Response to Planning Application

Application ref: BR/135/21/PL

Description: Three storey side extension, additional 16 double bedrooms with en-suite, lift & additional living accommodation (resubmission following BR/234/20/PL). This site is in CIL Zone 4 (Zero Rated) as other development.

Location: Aronel Cottage Nursing Home 5-11 Highfield Road Bognor Regis PO22 8BQ

LANDSCAPE LAYOUT PLAN, Ss: 1:200

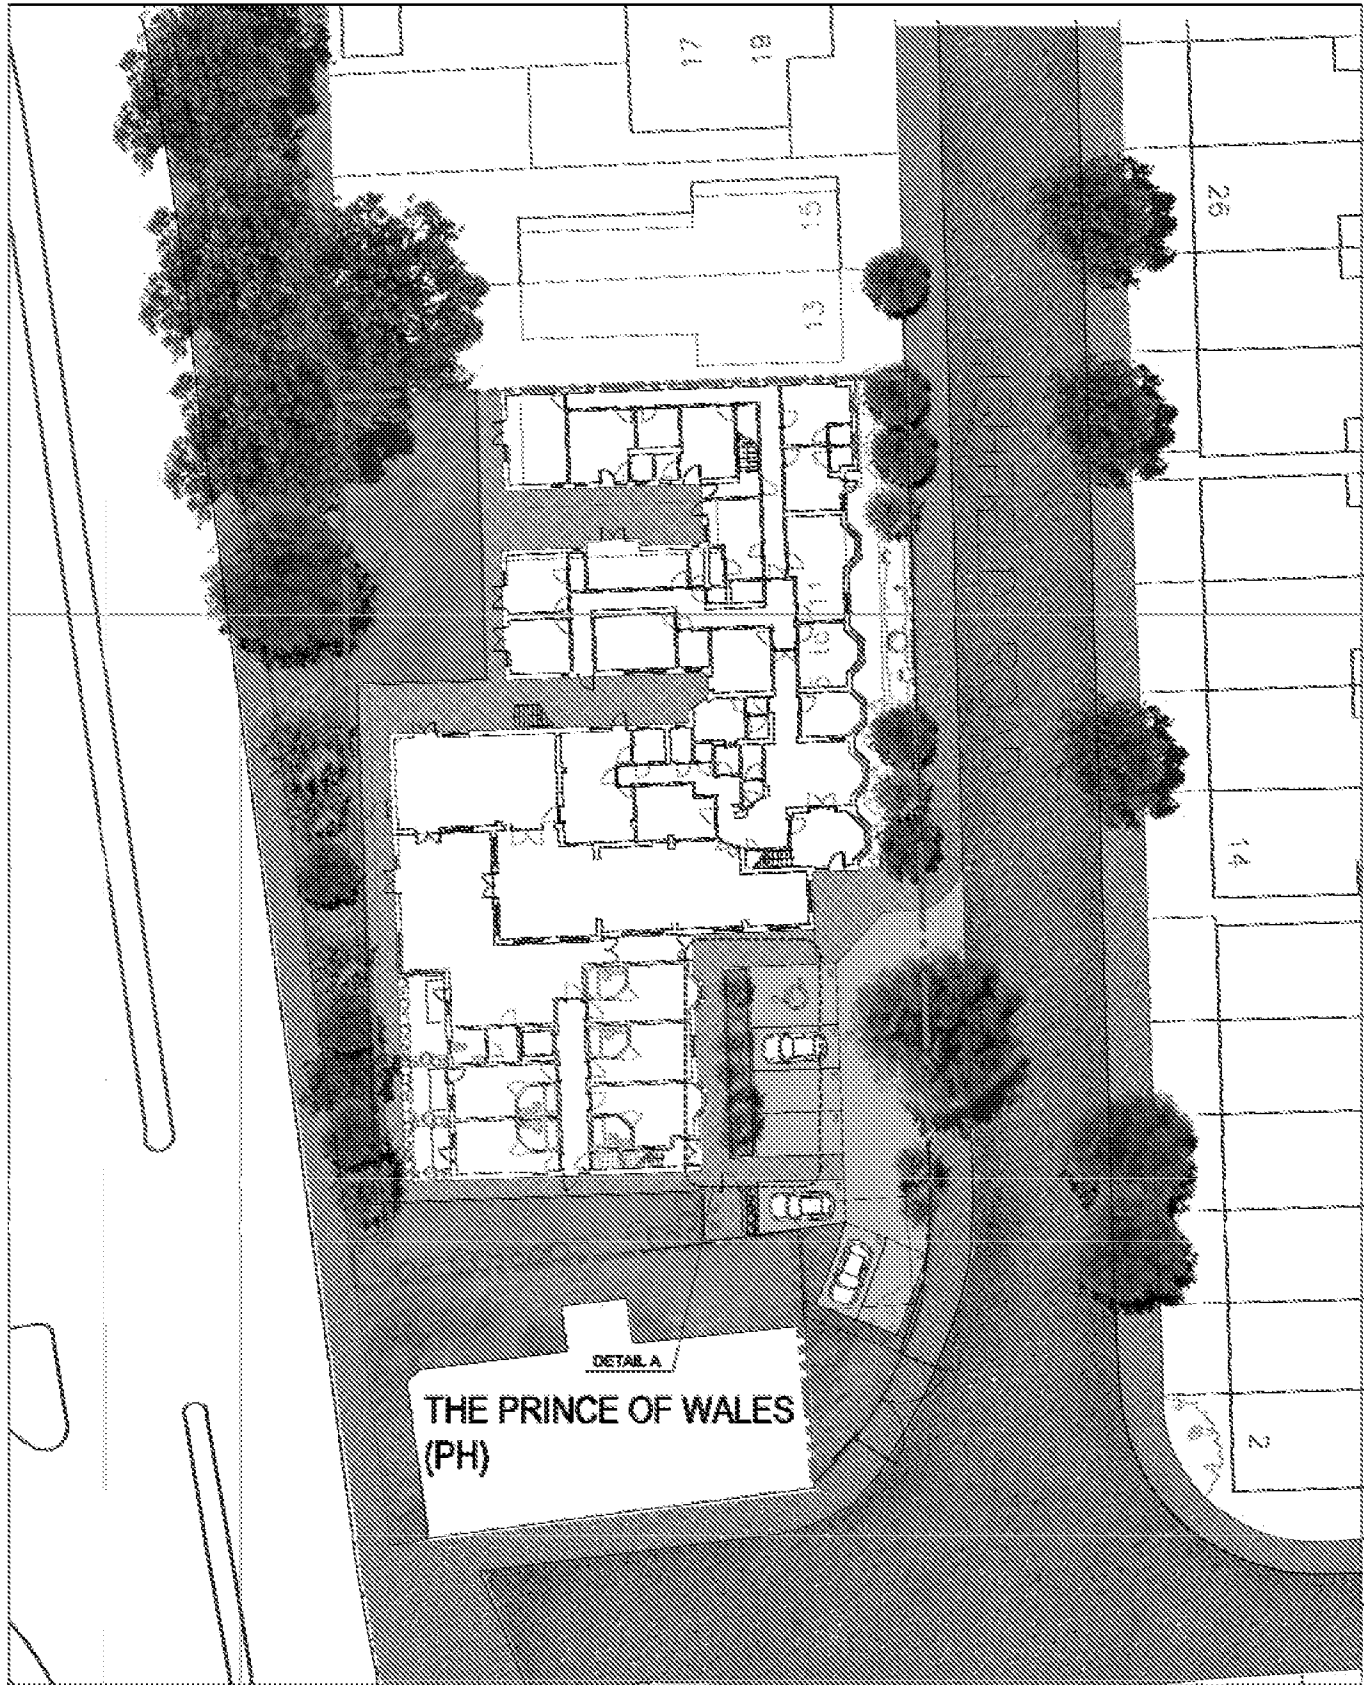
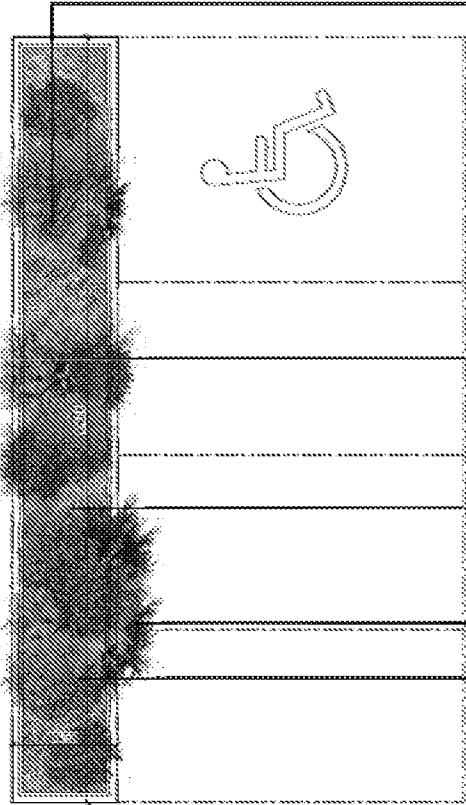
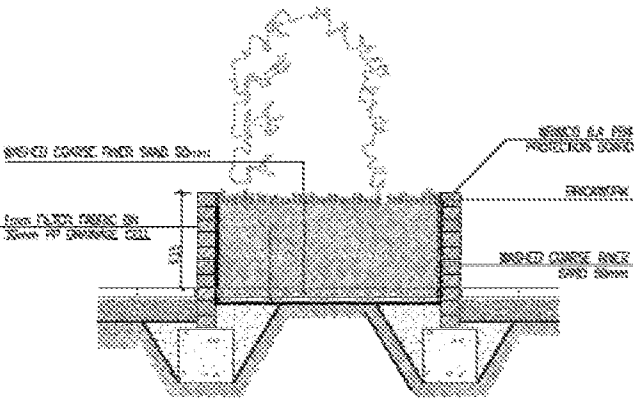
The potential impact of the proposals would blend into the surrounding environment, there would be little space for onsite green infrastructure in the form of any screening however some greening to the car park area would be required, which has been shown in the form of a raised planter.

Landscape mitigation in the form of raised planter as above, plan to show plant species and quantities.
